About the application

Application number: 2024/90256	
What is the application for?:	Change of use from coin operated jet wash to attended hand car wash
Address of the site or building:	Whitehall Service Station, Whitehall Road East, Birkenshaw, BD11 2EJ
Postcode:	B26 2SB

Site Location Plan (1:500)

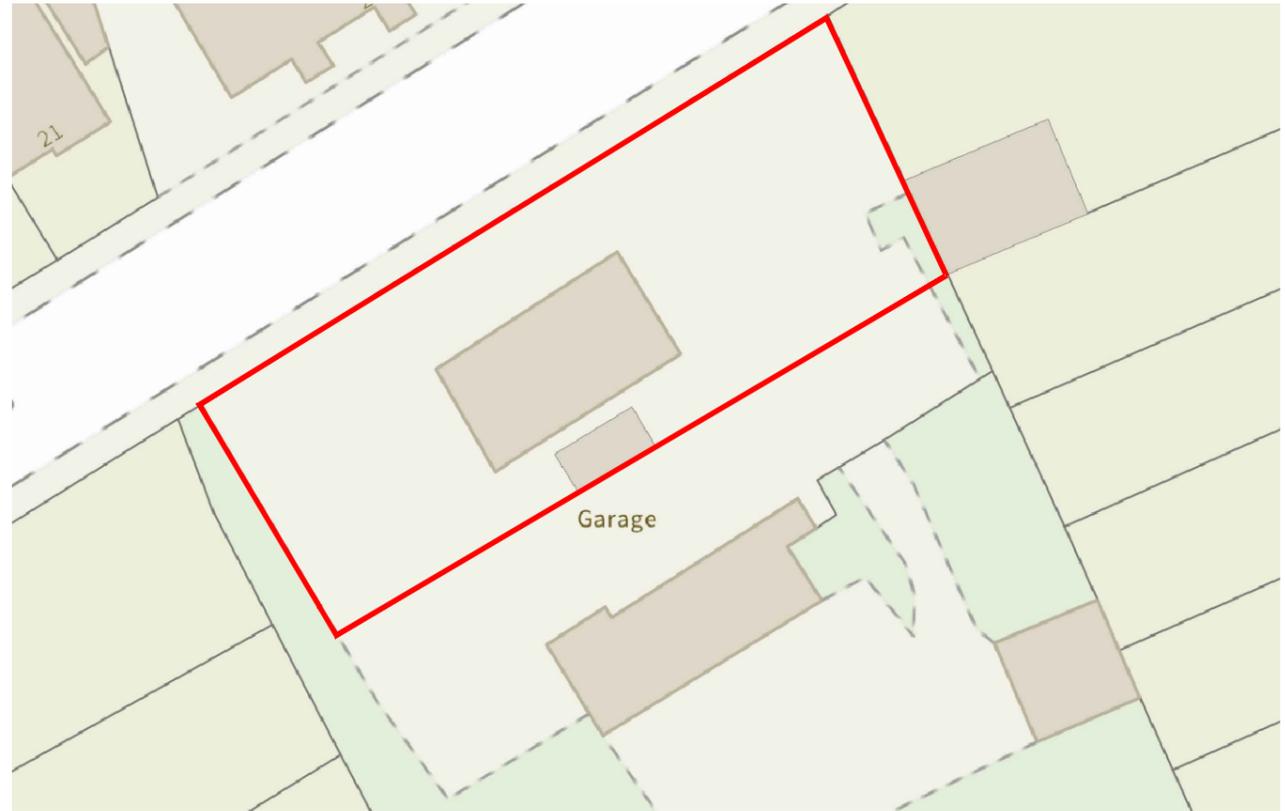
Type of comment: An objection	
Do you wish your comments to be published on the website anonymously?	<input type="checkbox"/> Yes
<p>The proposal and the plans submitted do not align. The wash bays and drying bays that would be next to each other, clearly would not flow. Going from one to another will cause issues with those using the petrol pumps. Cars already Q to get in the station without adding this in.</p> <p>The road is already busy, and this will only make this worse. There is poor drainage, the road is always soaked when the manual washer is used never mind what will happen with a hand wash, especially in winter.</p> <p>It's not in keeping with the local area and many other hand car washes attract trouble</p>
